22<sup>nd</sup> September 2020

Planning Application 3/2020/0602 Holden Clough

Proposed Ground Floor Plan

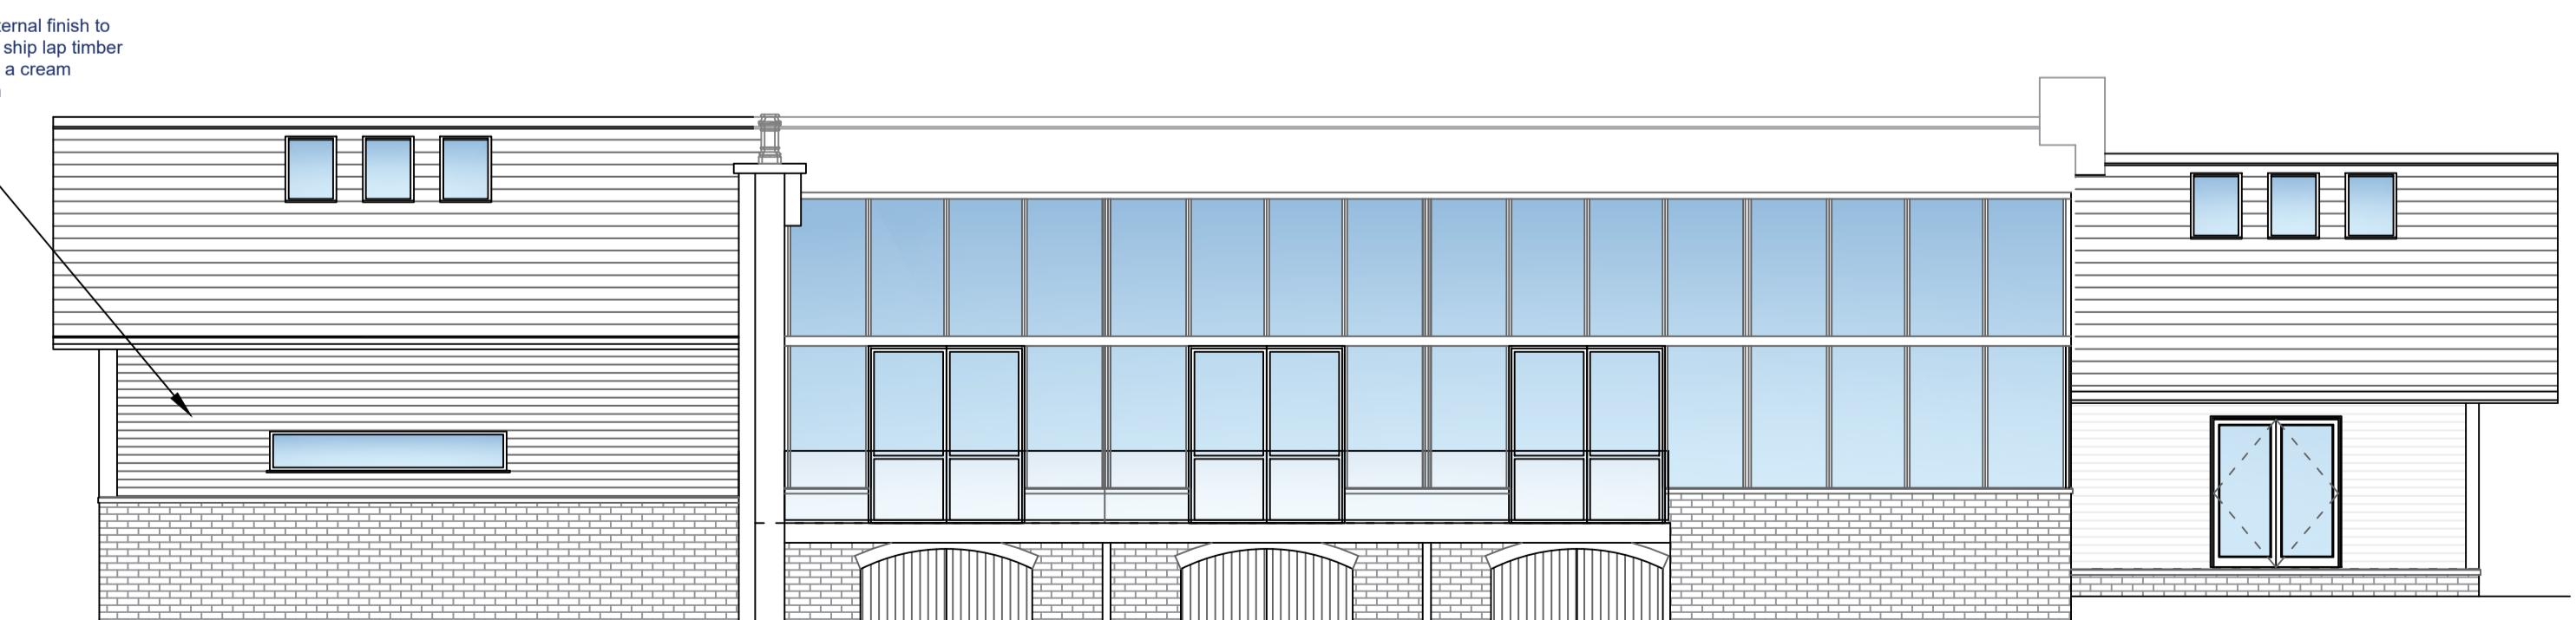
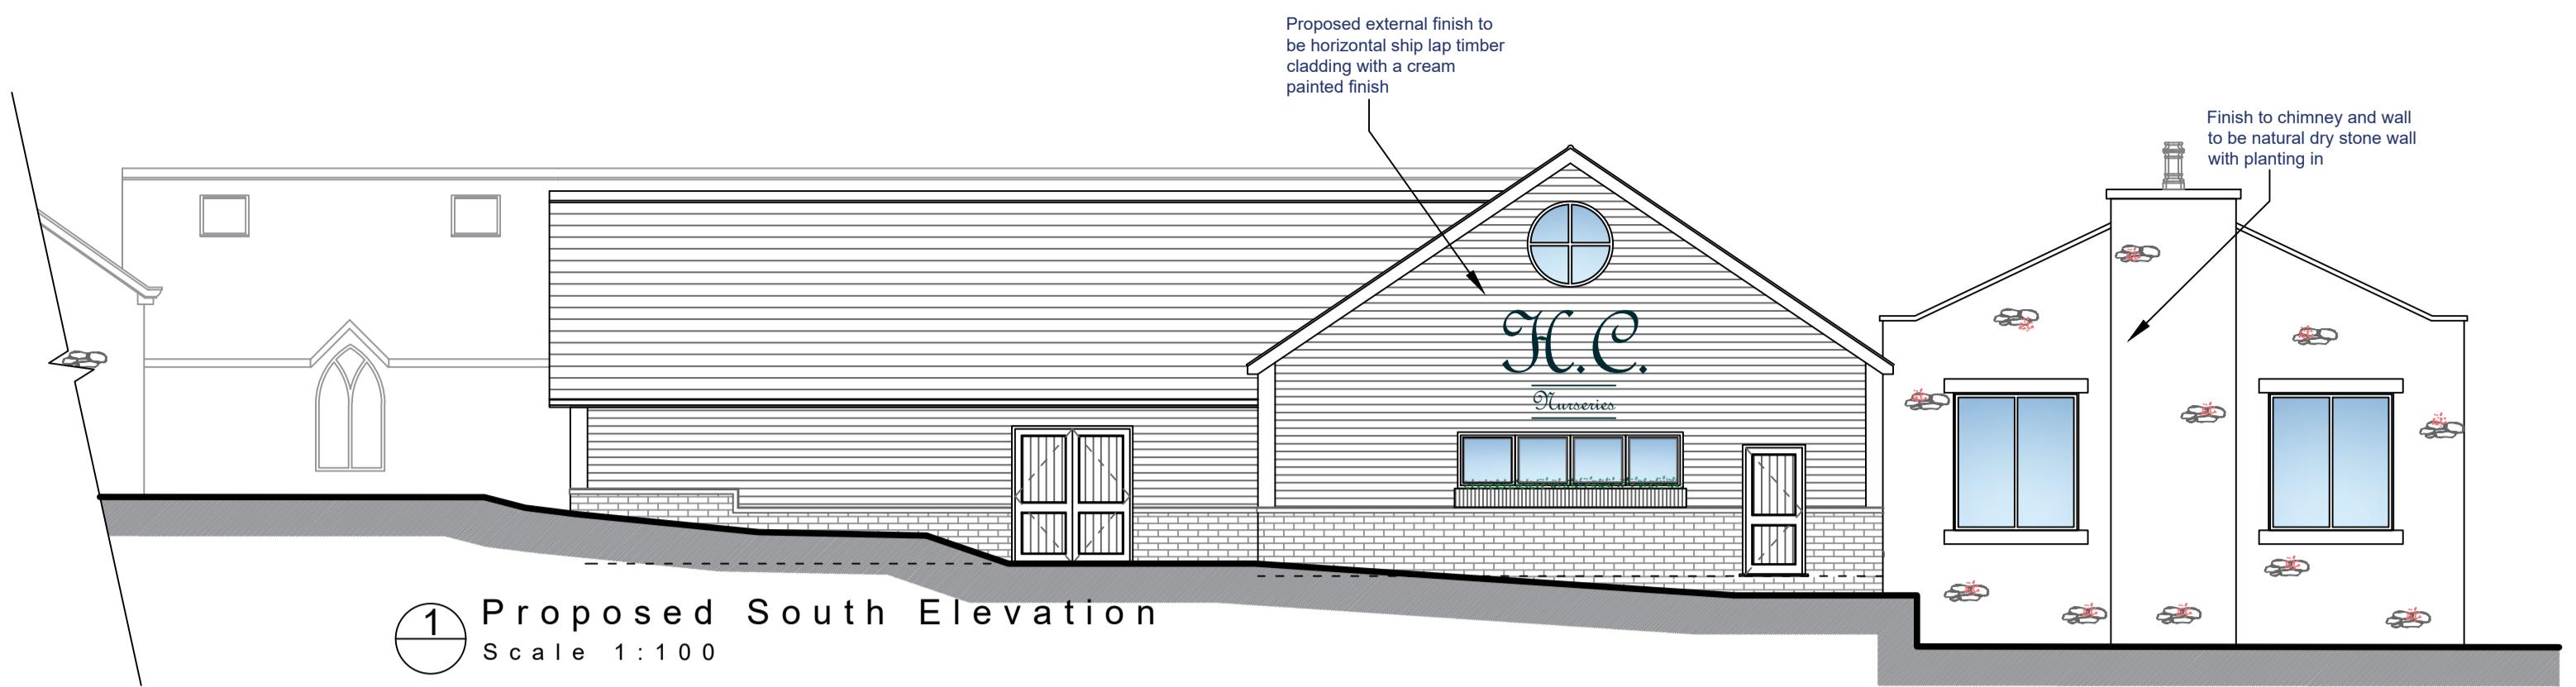
The proposal for an increase in floor space, both inside and outdoors amounts to an additional 80% which is a considerable expansion for what is possibly a temporary need for social distancing measures. Ultimately this will give rise to an increase in dining covers.

The application for an enlarged kitchen would also suggest that future plans are to increase the catering facility and will ultimately make larger social functions more feasible.
